Application number: 2023/62/91405/W	
What is the application for?:	Erection of foodstore (class E) with associated access, parking, servicing area
Address of the site or building:	Part of former St Luke's Hospital site, Blackmoorfoot Road, Crosland Moor, Huddersfield, HD4 5RA
Postcode:

Type of comment: A general comment	
Do you wish your comments to be published on the website anonymously?	No
2023/62/91405/W	
<p>Sorry for my very late application regarding concerns. I have only just seen the amended plans.</p> <p>General plan Identity 1022241 18/12/2023 shows the proposed road layout at the junction of Turnstone Way/Blackmoorfoot Road.</p> <p>This is a very large junction, especially if you are trying to cross with small children, are pushing a pram, or wheelchair or use a walking aid. I am very concerned about the fact that there is not going to be a pedestrian refuge/island in the middle of the road, where pedestrians can wait in safety whilst trying to cross this busy road.</p> <p>It is a death trap waiting to happen for a blind person or visually impaired person trying to negotiate crossing the road as there is no tactile paving areas on either side of the road, yet just a few

project  
Blackmoorfoot Road  
Huddersfield  
drawing title  
Proposed Site Plan

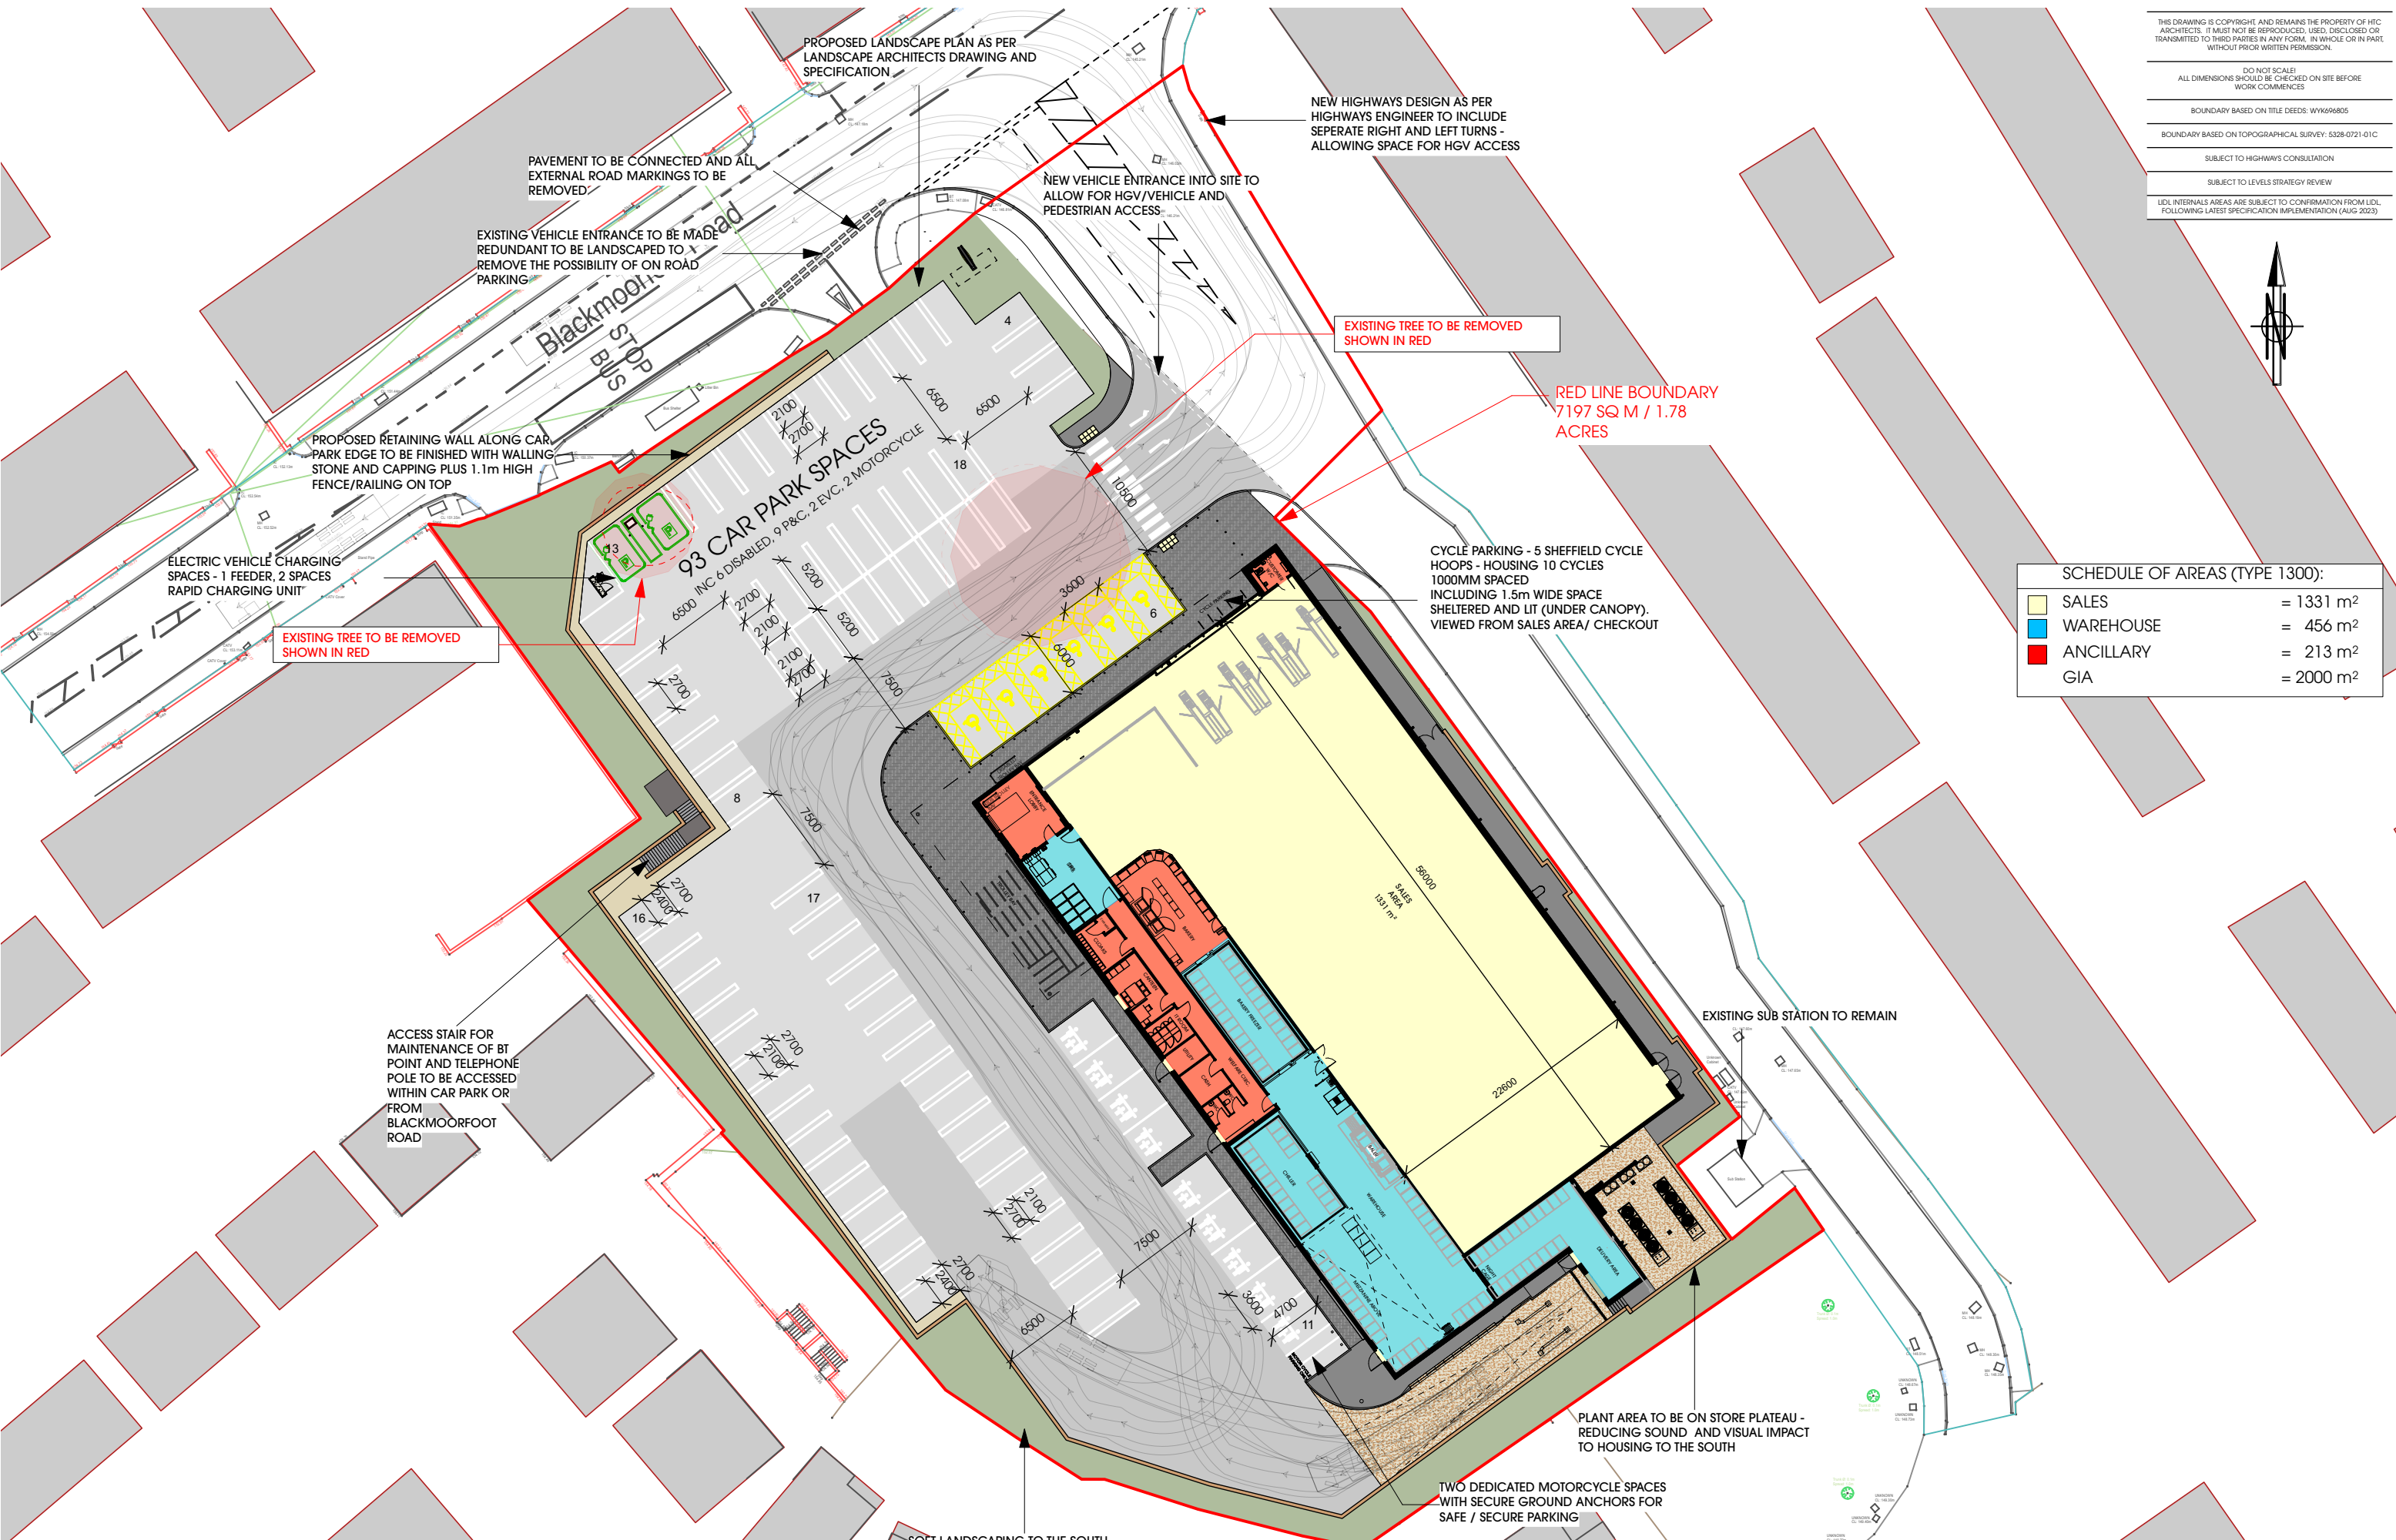
Because of the width of Turnstone Way at the junction of Blackmoorfoot Road, it is used by local taxi drivers, takeaway delivery drives and general motorists as a turning point, many a time I have turned onto this road and had the car in front of me just brake and then do a u-turn so that they can turn back down Blackmoorfoot Road with no warning nearly causing me to crash into the back of them.

If there were a pedestrian refuge/island then they would not be able to do a u turn

I am assuming that there will be double yellow lines at the junction of Turnstone Way/Blackmoorfoot Road that extend on Turnstone Way to where the turning into the new Lidl site will be.

I am not opposed to Lidl or any other retail development, but that junction needs a pedestrian refuge and tactile paving.
